WEST SUSSEX COUNTY COUNCIL CONSULTATION

TO:	Arun District Council FAO: Mr. S. Davis
FROM:	WSSC - Highway Authority
DATE:	9 March 2022
LOCATION:	Land to the south of Ford Lane and east of North End Road Yapton BN18 0DS
SUBJECT:	Y/10/22/PL Erection of 15 No dwellings (including 4 No affordable units) with associated access, parking, landscaping, drainage and public open space (additional units to those approved under application Y/123/21/PL). This application may affect the setting of a listed building, affects the character & appearance of the Church Lane Conservation area, affects a Public Right of Way and is in CIL Zone 2 and is CIL Liable as new dwellings.
DATE OF SITE VISIT:	n/a (visited previously for other applications on the site)
RECOMMENDATION:	More Information Required
S106 CONTRIBUTION TOTAL:	TBA

Drawing Title Sections through public right of way footpath 357

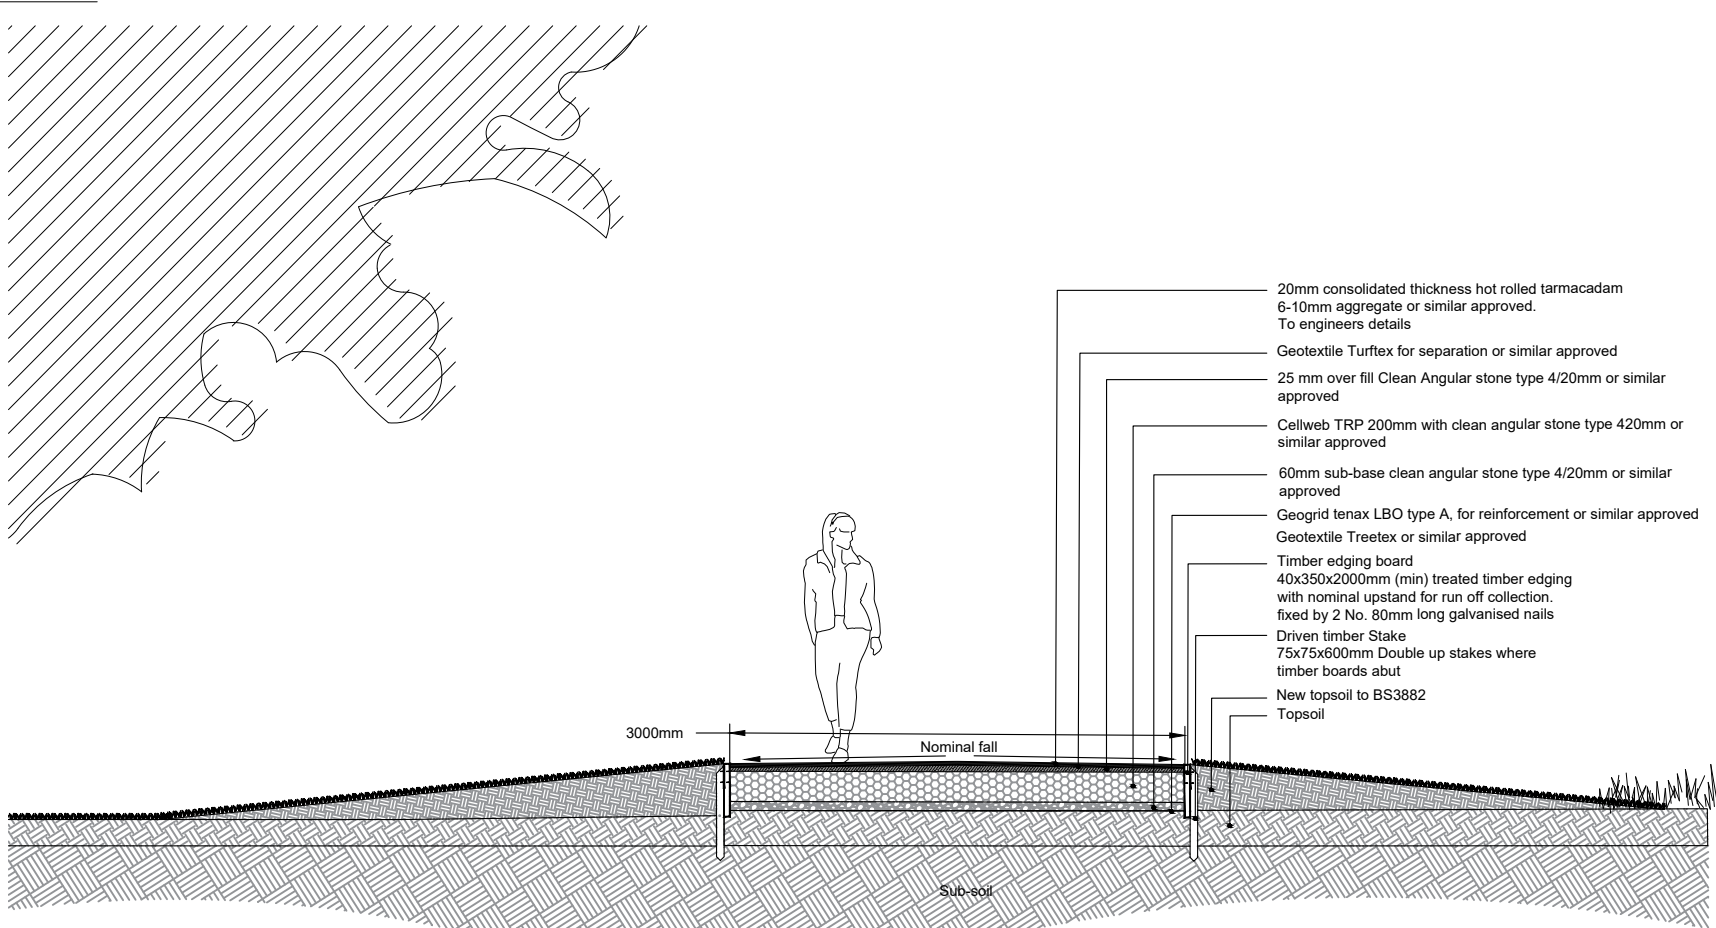
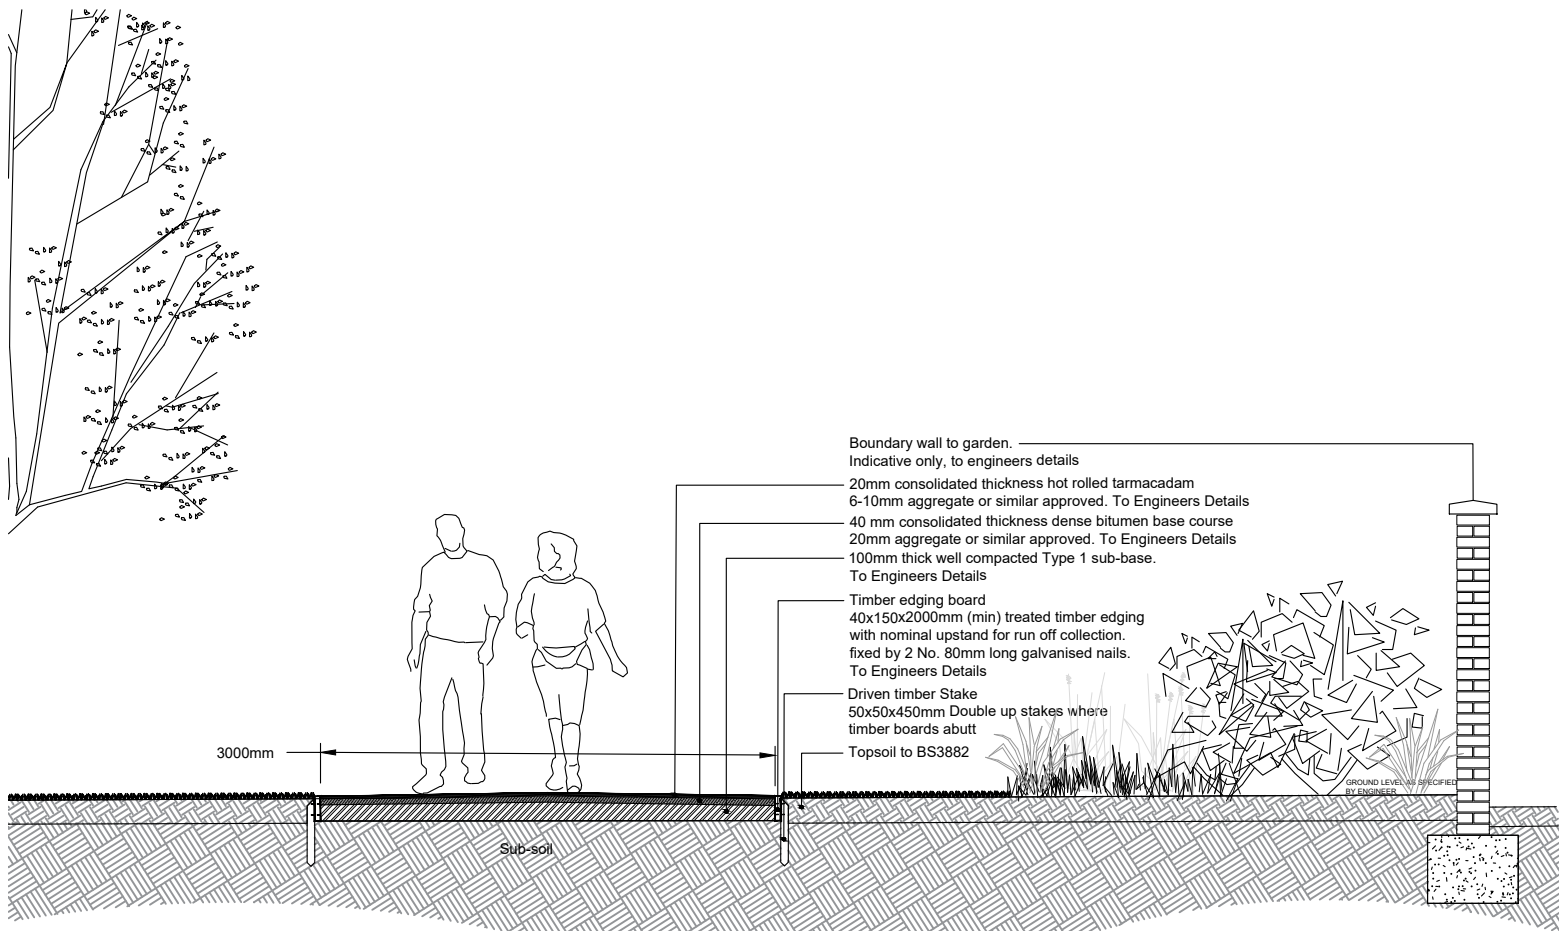
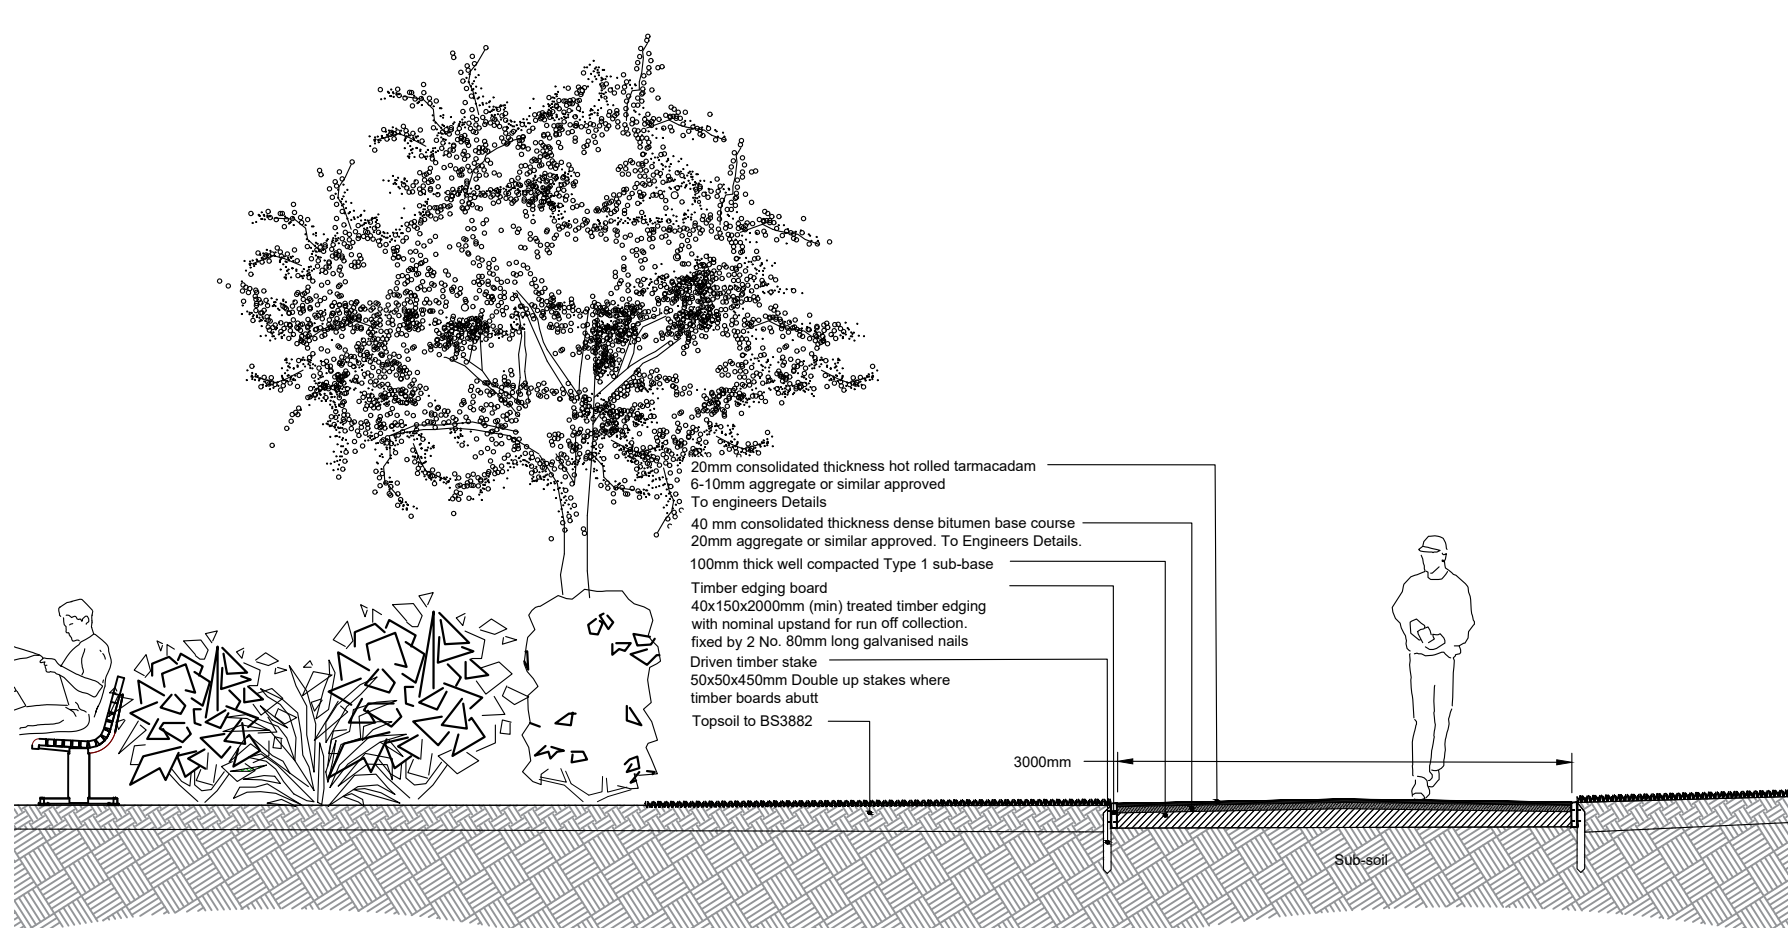
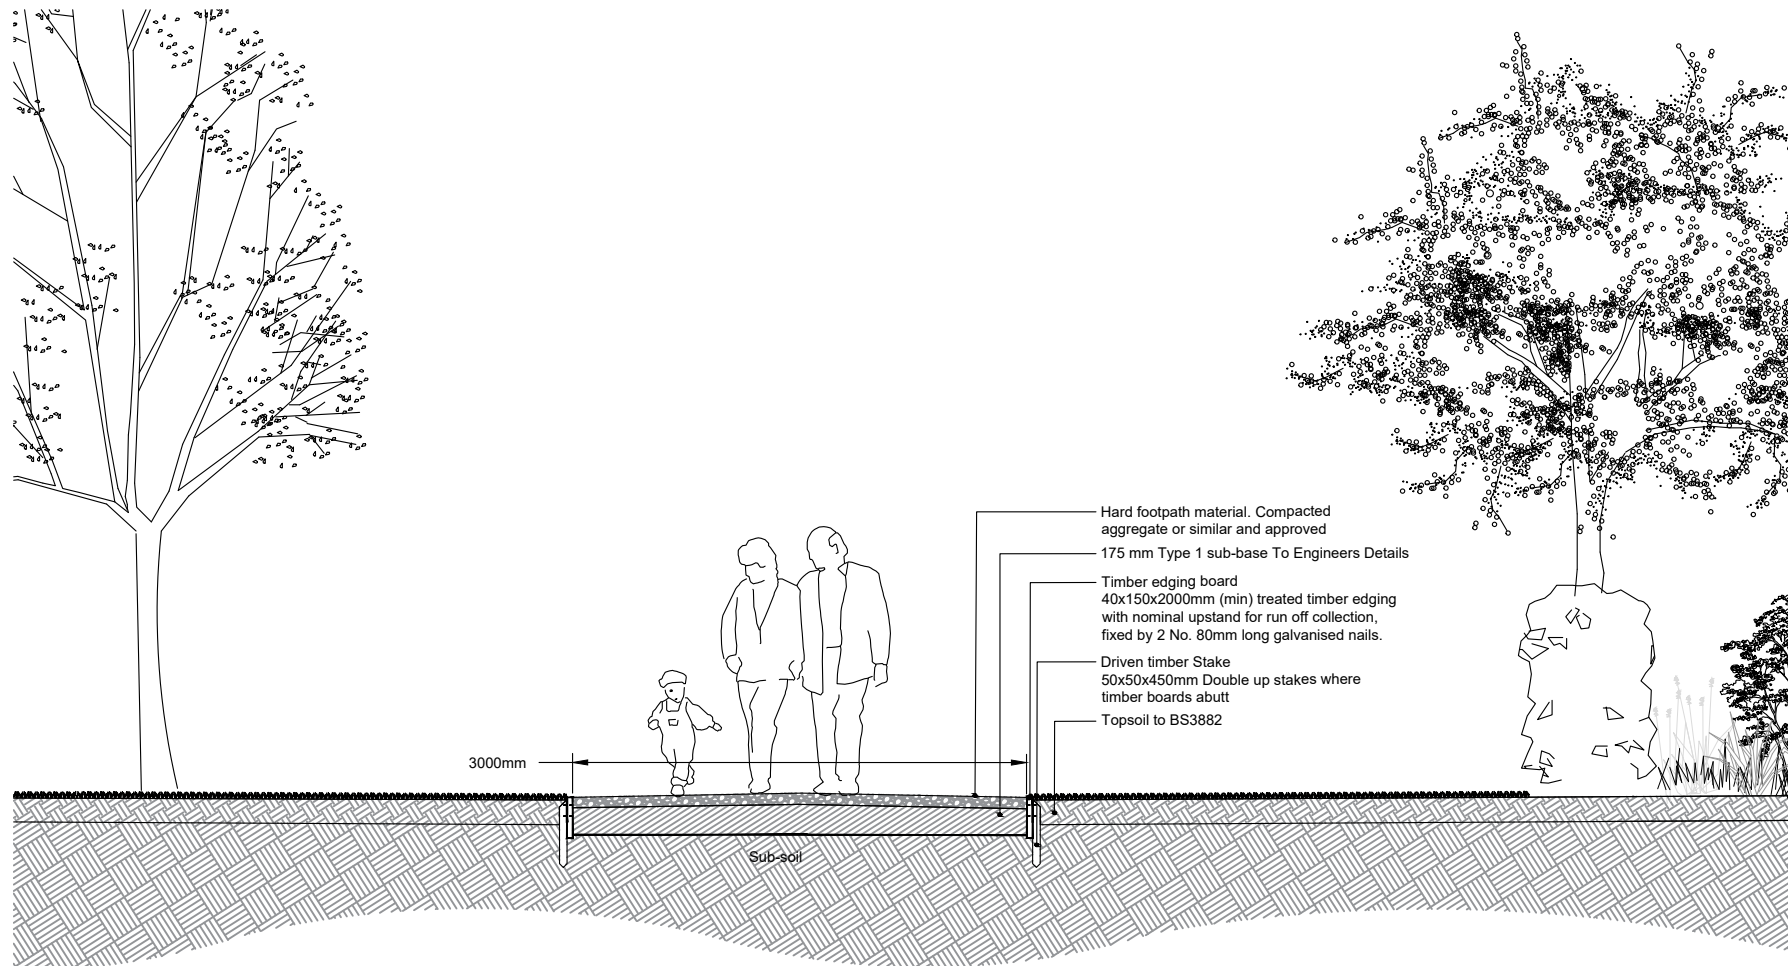
PRoW – Applicant to provide clarification about surface treatment of PRoW 357 (as it looks to be paved) and further detail of the termination point alongside eastern-side of the turning head referred to above.
